Reviewed for Code Compliance
Inspections Division
Approved with Conditions

ROSIE'S - New Awning

Signage / Awning Permit Application

ROSIE'S - New Awning

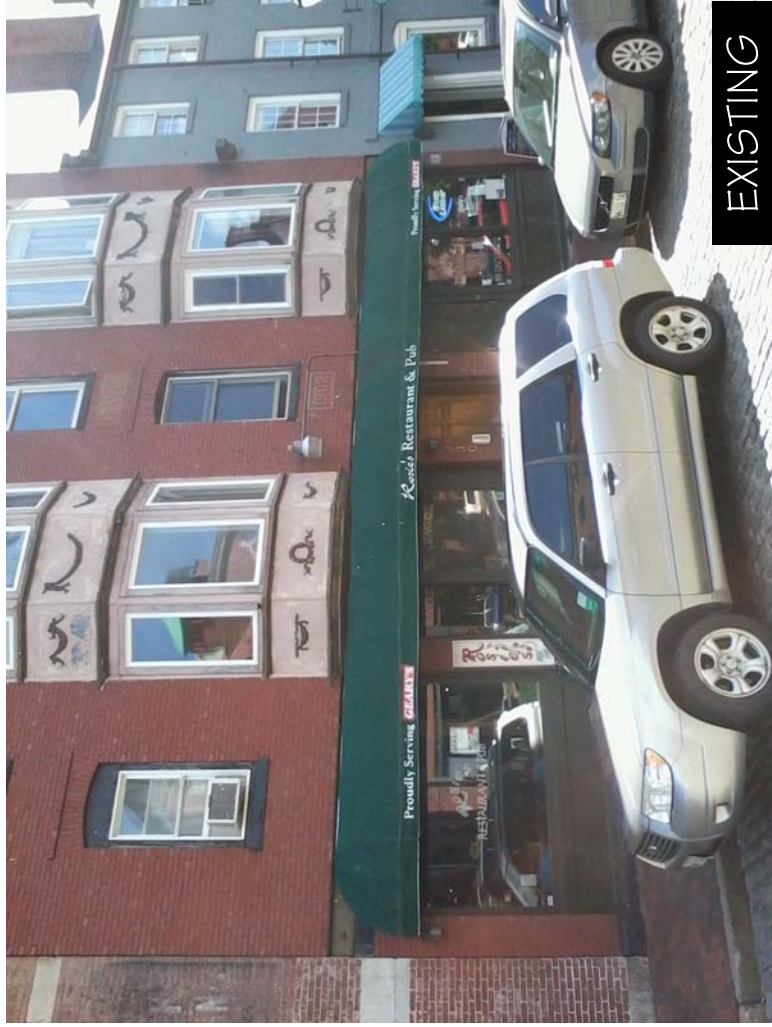
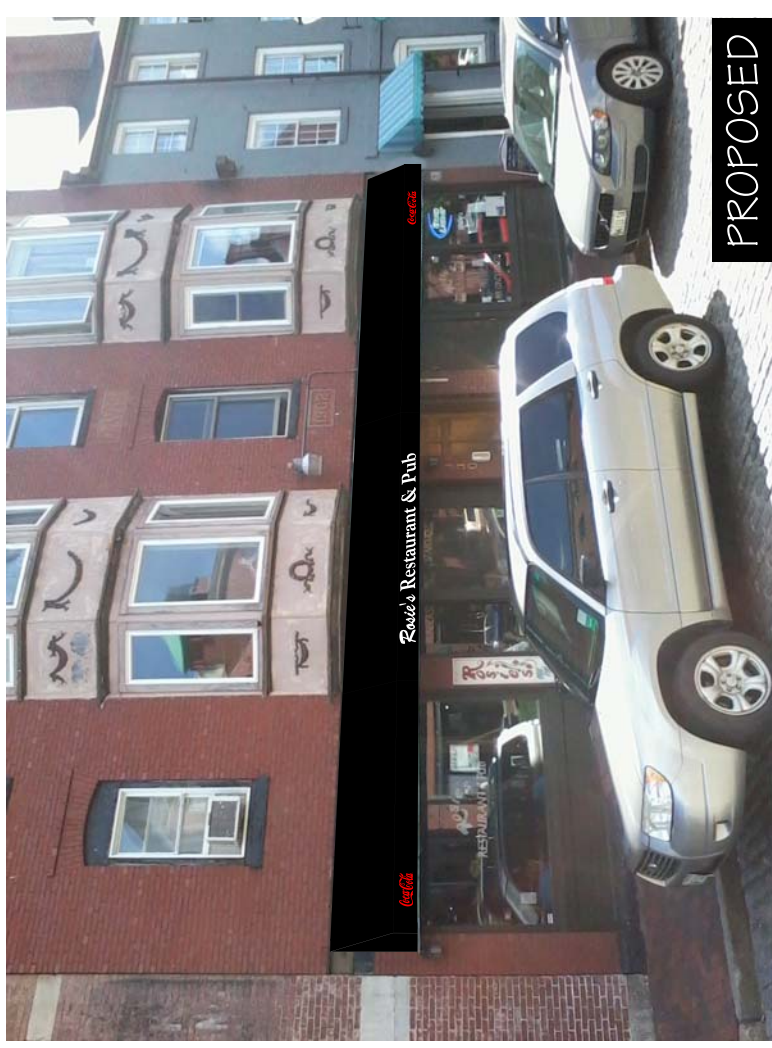
Awning to
end at edge
of window
opening.

Coke logos are not to be included on awning.
